DECISION DELEGATED TO DEVELOPMENT MANAGER

Application No:	H09-0122-21	Applicant:	Wilf Hammond Homes Ltd.
Proposal:	Proposed residential development - 4 dwellings		
Location:	Land At Chapel House Chapel Drove Holbeach Drove		
Terminal Date:	9th May 2021

DRAWING
PLANNING DRAWING 1
SITE / LOCATION PLAN

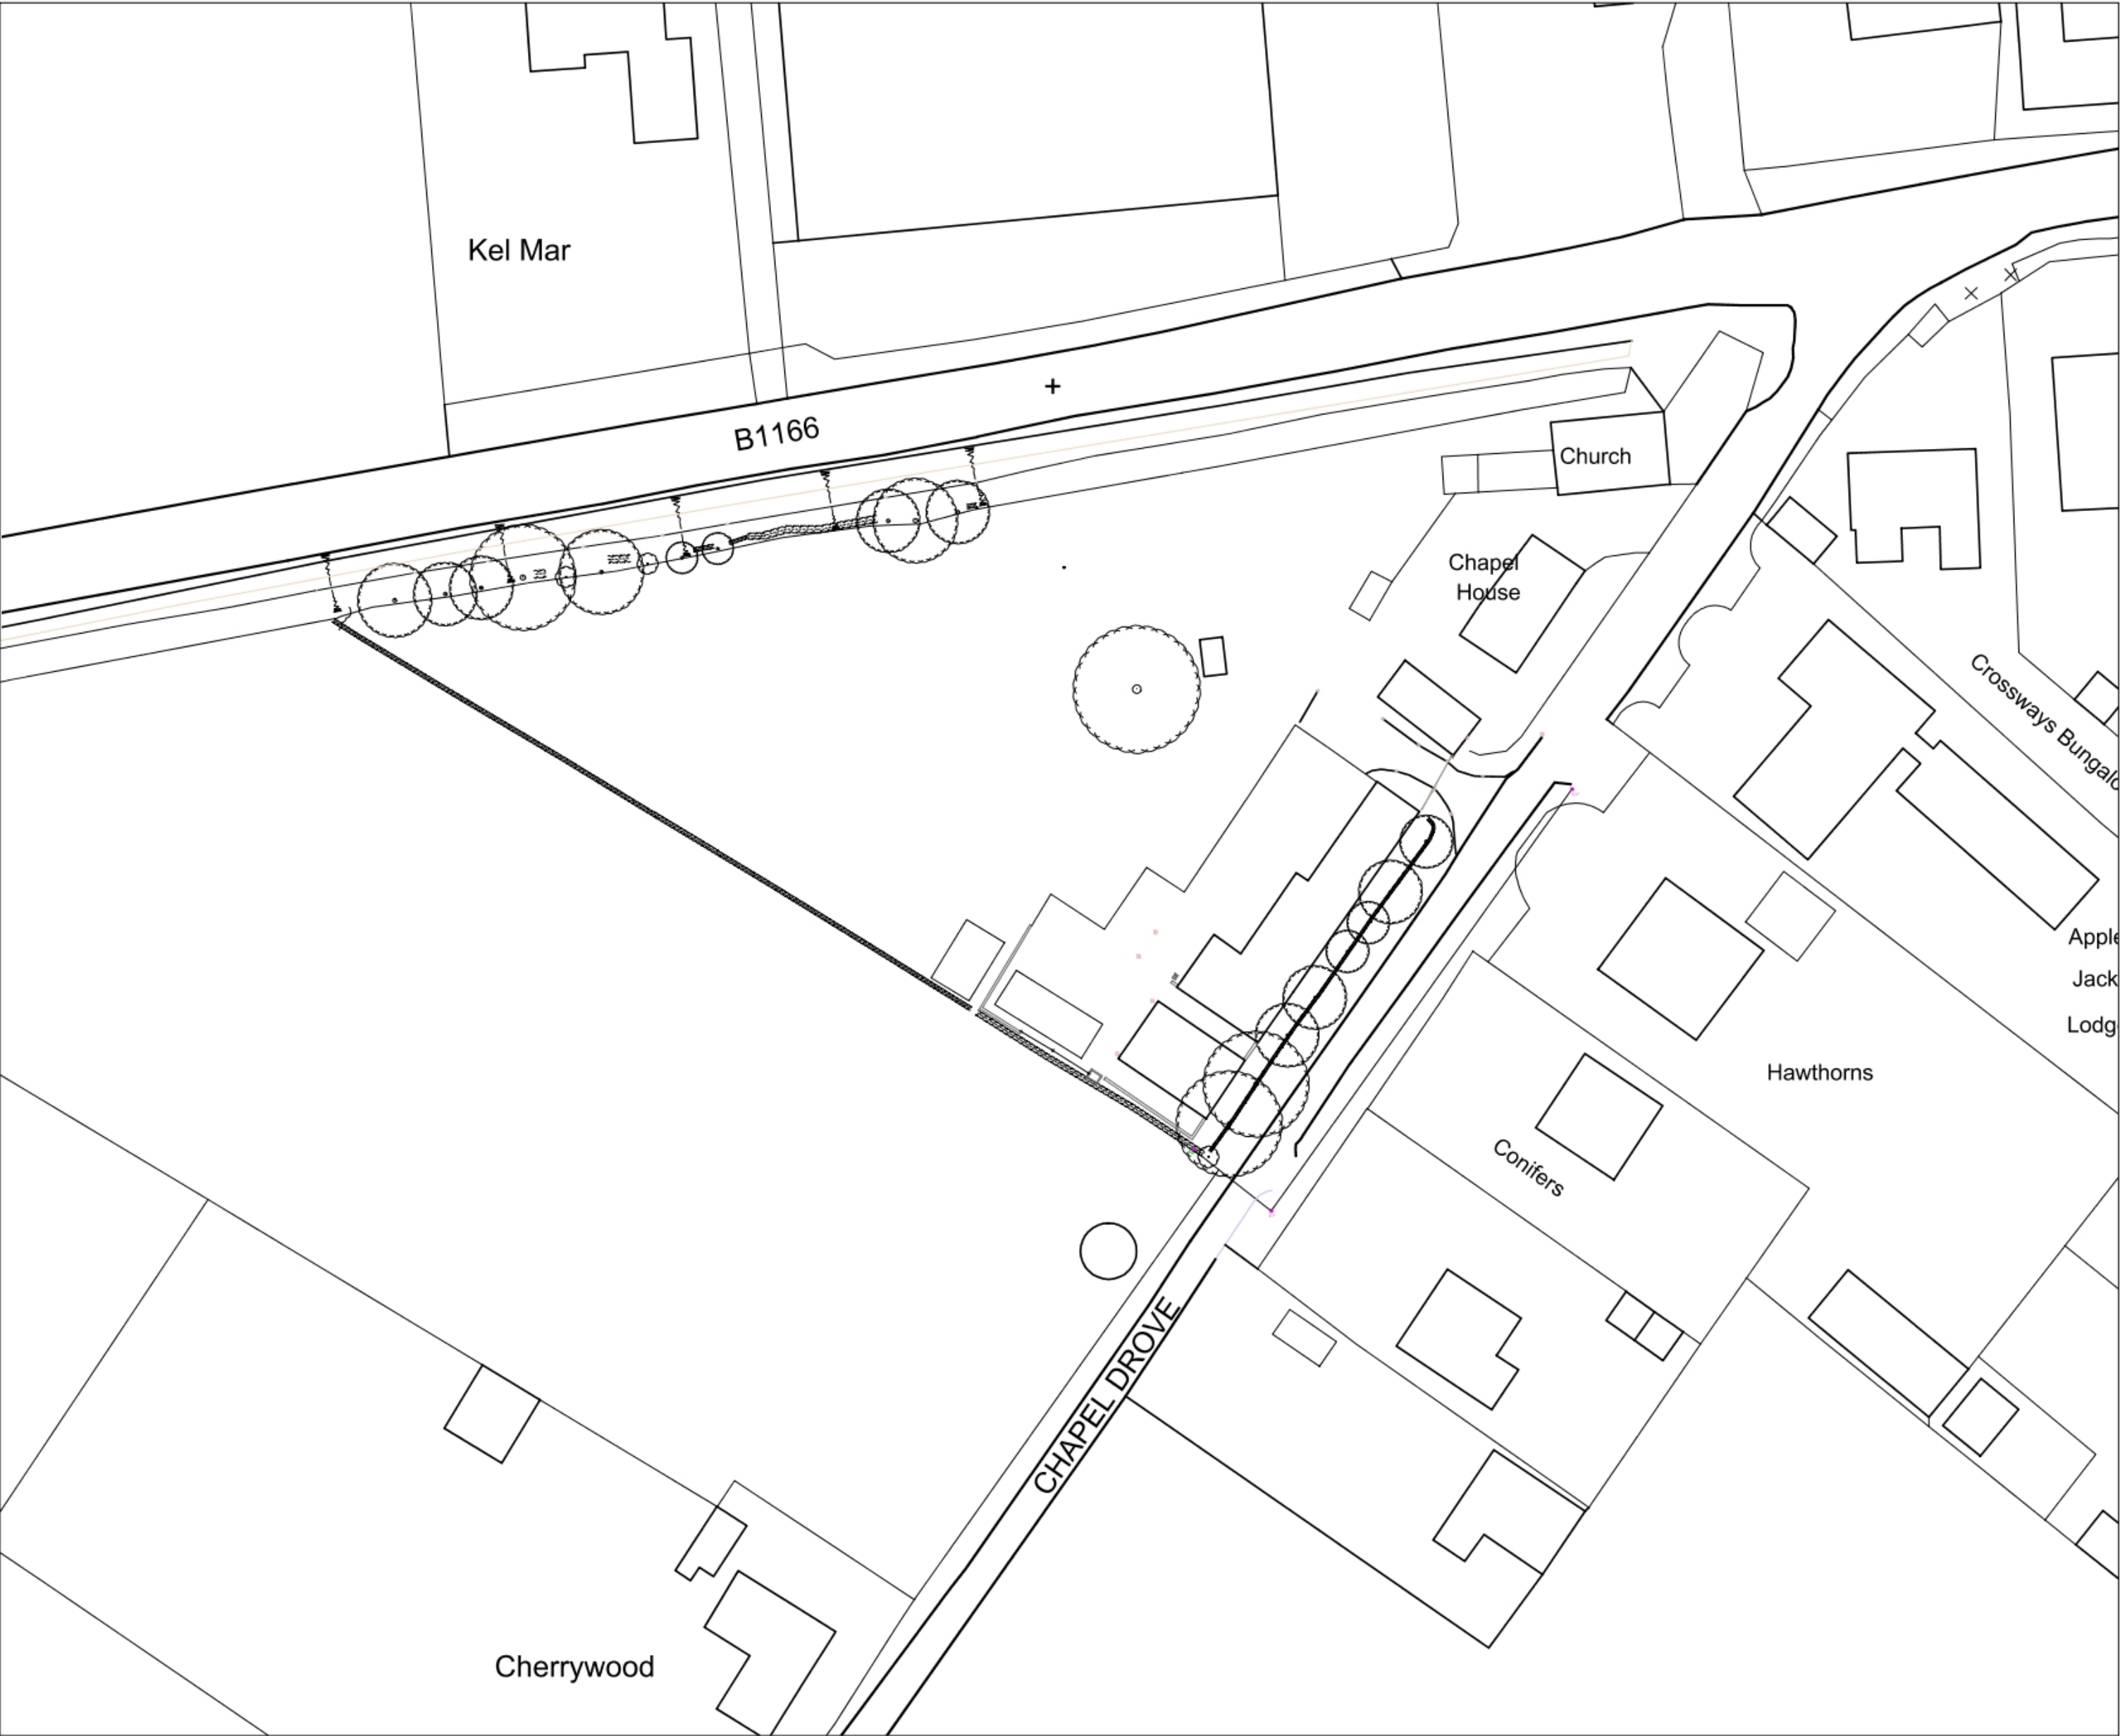
SHIDB - The Board are pleased to observe that plot 3 has been moved outside of the Board's 9 metre easement/maintenance strip. understand that the existing trees/ hedges are to be retained. We have also had discussions with the applicant, that have led to an understanding that no additional trees/hedges will be planted within the 9m easement, as to not further restrict the Boards access to maintain the watercourse.

Two houses would front the B1166 and two would face Chapel Drove. Existing properties along the latter within the immediate vicinity are houses. Although an existing tree within the centre of the site would be removed existing trees fronting Chapel Drove and the B1166 would be retained.

A new shared vehicular access serving plots 3 and 4 would be formed onto the B1166, with a piped culvert and block paved vehicular turning facility. A pair of accesses would be formed onto Chapel Drove serving plots 1 and 2. Satisfactory on-site parking would be provided. LCC Highways have raised no objections on highway safety grounds.
